From: John Marvin <jmarvin@Yakama.com>
Sent: Friday, February 19, 2016 11:18 AM
To: Lindsey Ozbolt
Cc: Doc Hansen; Cialita Keys
Subject: Re: Yakima River Campground CU-15-00002 Notice of Application
Attachments: YN to Kittitas Co on Yakima River Campground Feb 2016.pdf

RE: Yakima River Campground - CU-15-00002, SD-15-00001, SP-15-00001

TO: Phil Rigdon, Deputy Director, DNR
THROUGH: Scott Nicolai, Yakima Subbasin Habitat Coordinator, YKFP
FROM: John Marvin, Habitat Biologist, YKFP
DATE: Wednesday February 17, 2016
RE: CU-15-00002 Yakima River Campground

YAKIMA RIVER SHORT PLAT - SP 15-XXXXX
 A PORTION OF THE NORTH 1/2 OF SECTION 4,
 TOWNSHIP 19 NORTH, RANGE 16 EAST, W.M.,
 KITTITAS COUNTY, WASHINGTON

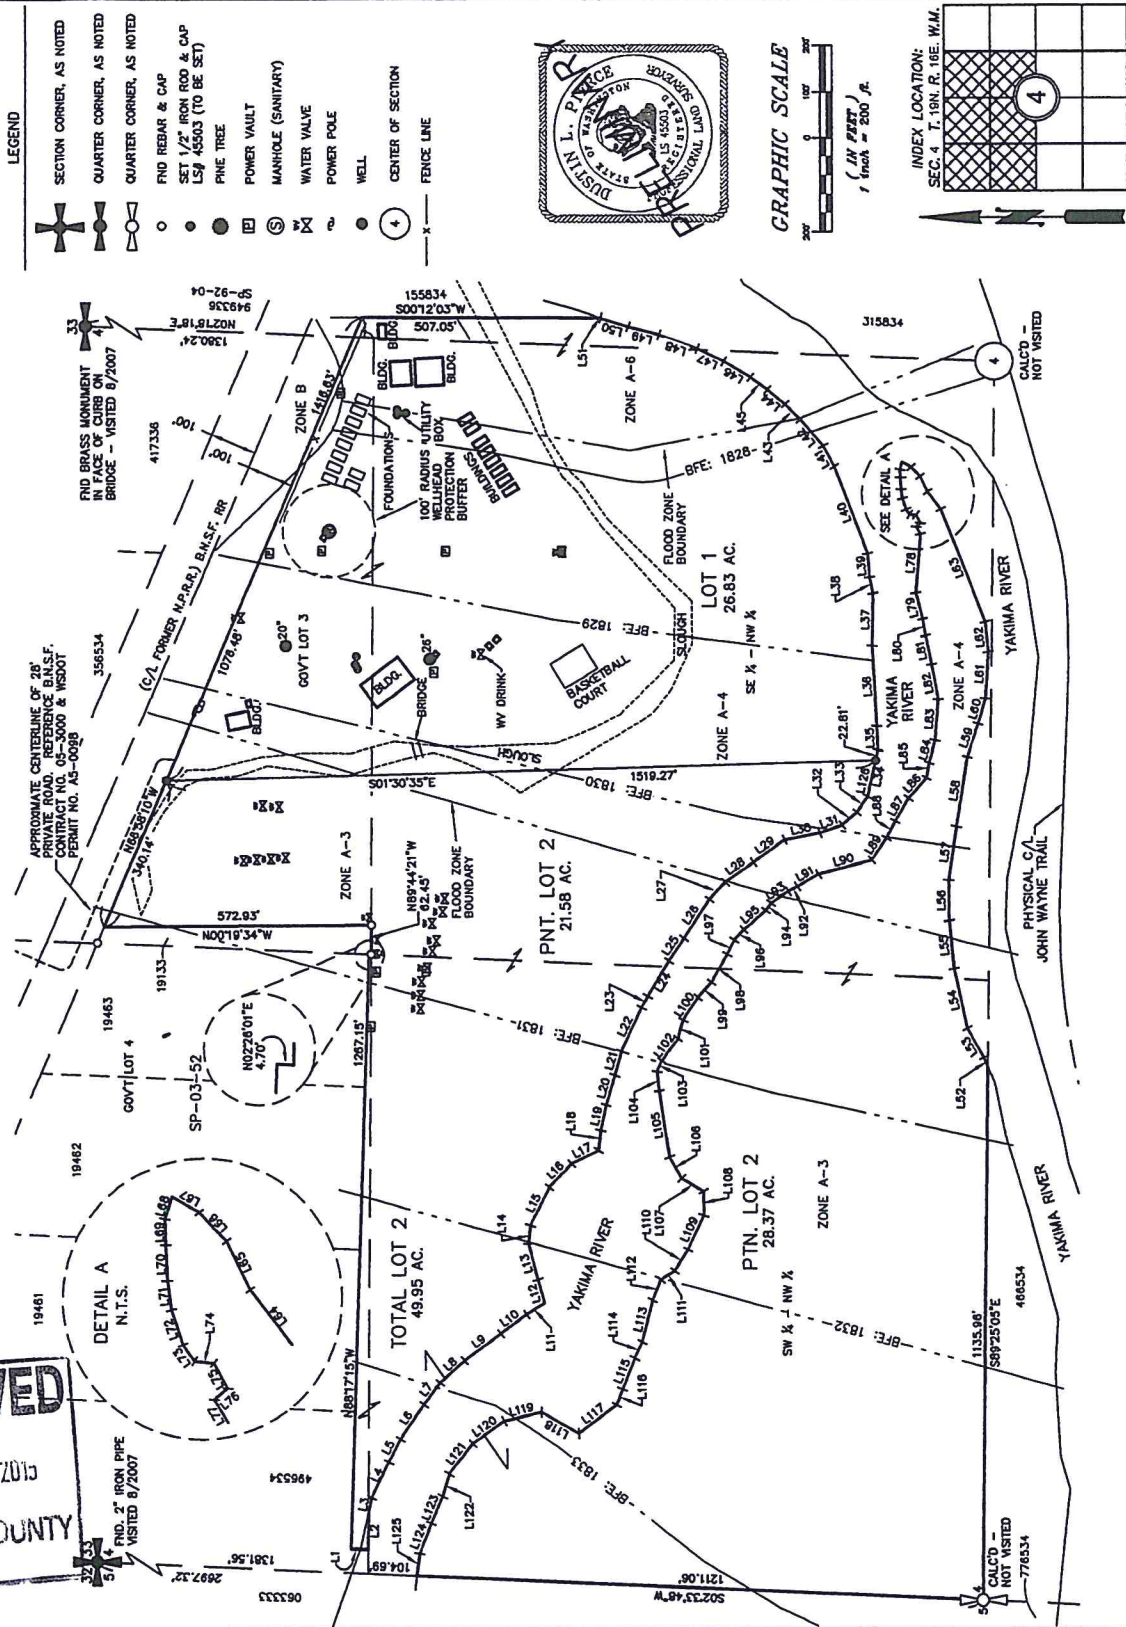
The site plan in the file indicates that a boat launch is proposed, yet there is no discussion of the boat launch in the project description or in the SEPA checklist. It is therefore assumed that a boat launch is not included in the proposal. The site plan also depicts an "existing road" through the floodway to the Yakima River. There should be no road there. The original approval of the camp was conditioned on leaving the floodway in its natural state as mitigation, no vehicles were to be allowed in this area. If there is an old road in this area it should be considered abandoned.

- 1) Deny development in the floodway without the inclusion of additional EIS analysis and mitigation.
- 2) Specifically exclude the boat launch from final approval, unless additional information is provided and the comment period re-notified.
- 3) Required buffers should be the maximum allowed by KCC 17A and the Kittitas Shoreline Master Program. Any critical areas/Shoreline functions and values impacted by the project should be fully mitigated accordingly, including, but not limited to requiring buffers to be restored with native vegetation as mitigation for increased impact by the proposed development.
